**APPLICATION REFERENCE NO: 147270**

**PROPOSAL: PINS consultation on behalf of the Secretary of State for its opinion (a scoping Opinion) as to the information to be provided in an Environmental Statement – EN020034**

**LOCATION: North Humber to High Marnham**

Figure 7-1. Proposed Visual Study Area

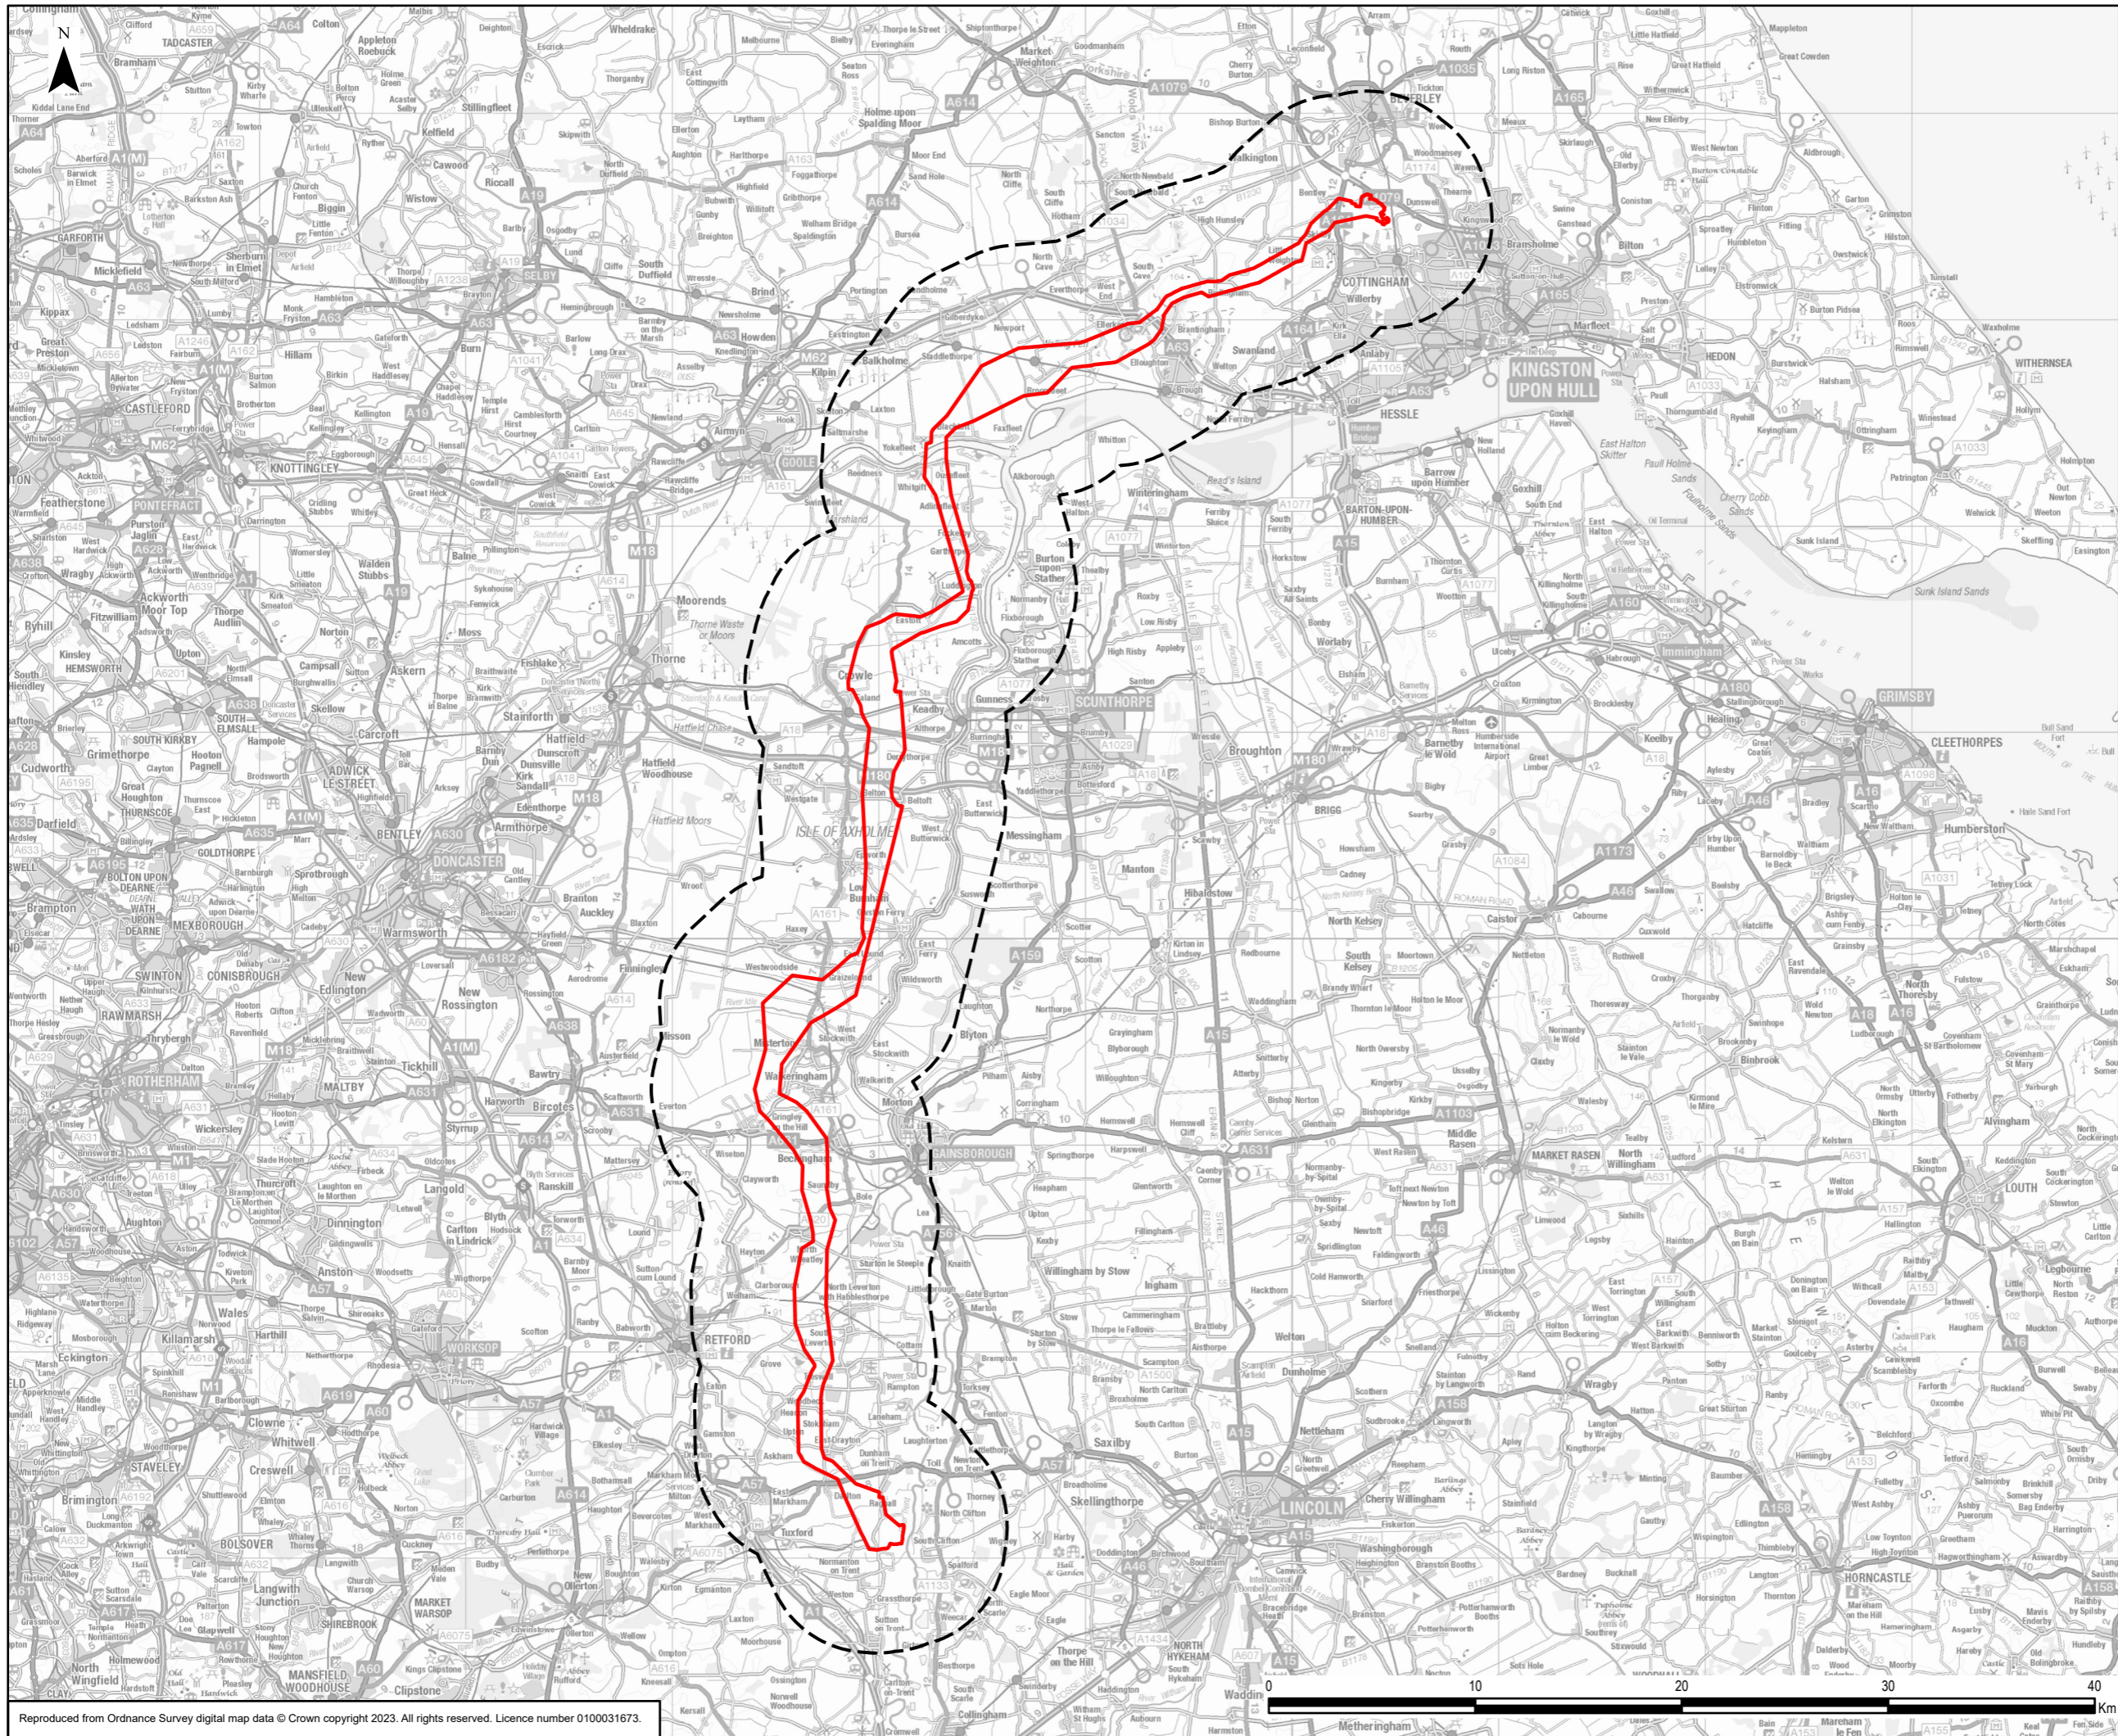
It is understood that the main focus would be on local/nationally protected landscapes but this should not be at the expense of the overall landscape character. The fact that Chapter 7 makes almost no reference to West Lindsey and no detailed consideration is surprising. The closest extent of the Scoping Boundary is just over 1 kilometre and goes up to being 3 kilometres from the western border of West Lindsey. The introduction to Chapter 7 outlines the following:

The text is taken from 7.3.2 to 7.3.4. Whilst the impacts are less likely to be significant on West Lindsey than other LPAs directly within the Scoping Boundary, the lack of any consideration is concerning. The first paragraph makes it clear that the study area is up to 10 kilometres and it is only at a distance of greater than 5 kilometres where the impacts are considered to be *'unlikely to be significant'*.

All relevant NCAs/LCAs within West Lindsey should be **scoped in** to the ES alongside consideration of all relevant development plan policies, including Neighbourhood Plans. This alongside Chapter 9 are the most important considerations to the Local Planning Authority and should be given an appropriate level of consideration.
